Notice of Intent to SUSPEND/REVOKE Improvement Permit/Construction Authorization
7-12-2024(Date)

Subject: Notice of Intent to Revoke/Suspend Camille Allen/115 Ithica Ln (SR 2499)(specify name/location) Improvement Permit/Construction Authorization

The Harnett County Health Department inspected the site for the on-site wastewater system located at 115 Ithica Ln (SR 2499) (physical address) for compliance with General Statutes 130A-334 to 345, 15A NCAC 18A .1900 et seq., and Improvement Permit/Construction Authorization SFD2309-0035 (specify type and number) conditions. As a result of this inspection, the Department has determined the following violations:

Harnett County Department of Public Health Site Sketch

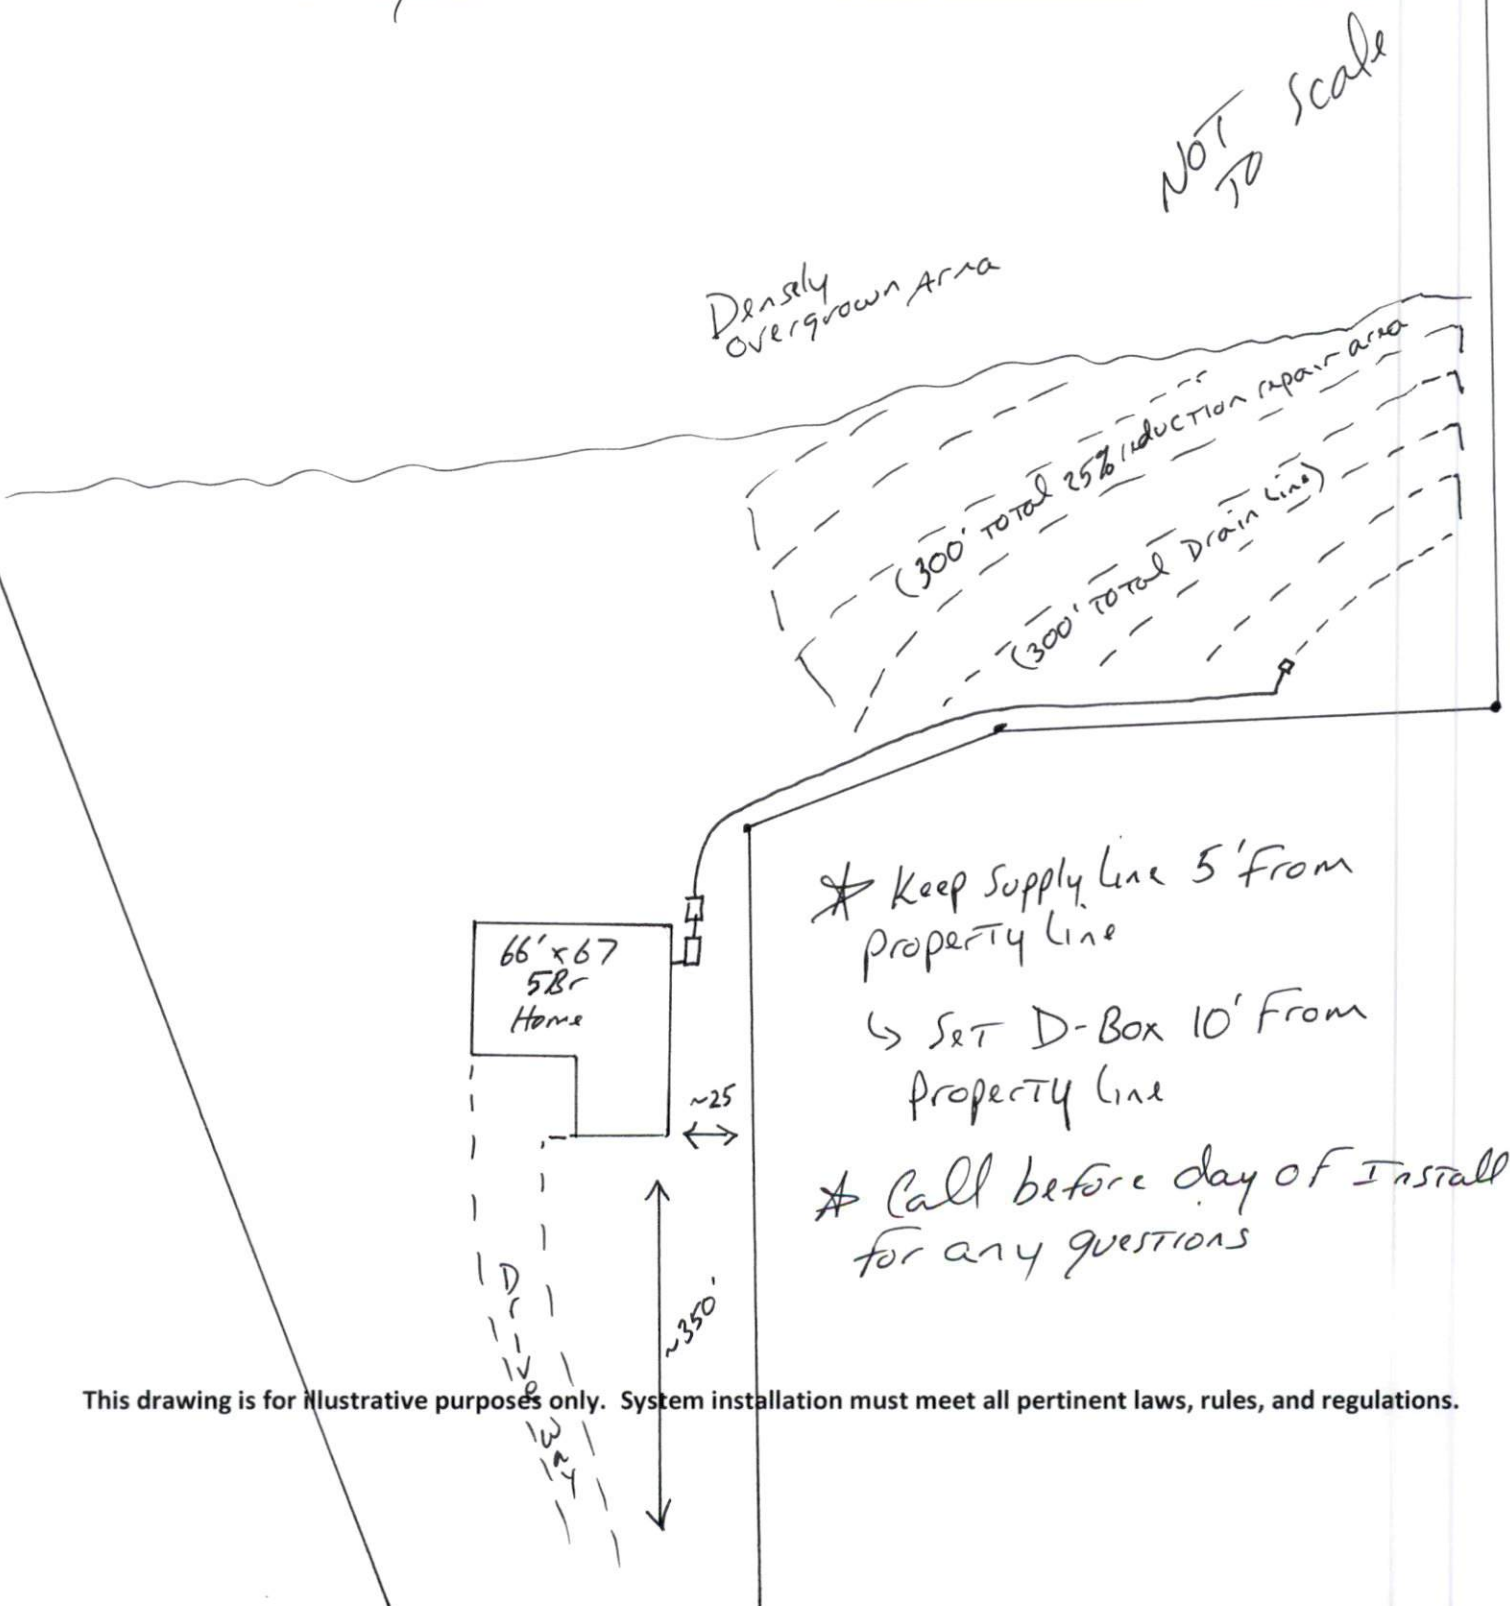
<u>Violation</u>	<u>Law or Rule Citation</u>
<i>House was moved into septic area and can not evaluate remaining usable septic area because lot is stoged on IT and workers are parking on it</i>	<i>15A NCAC 18E. 1406 (4)</i>
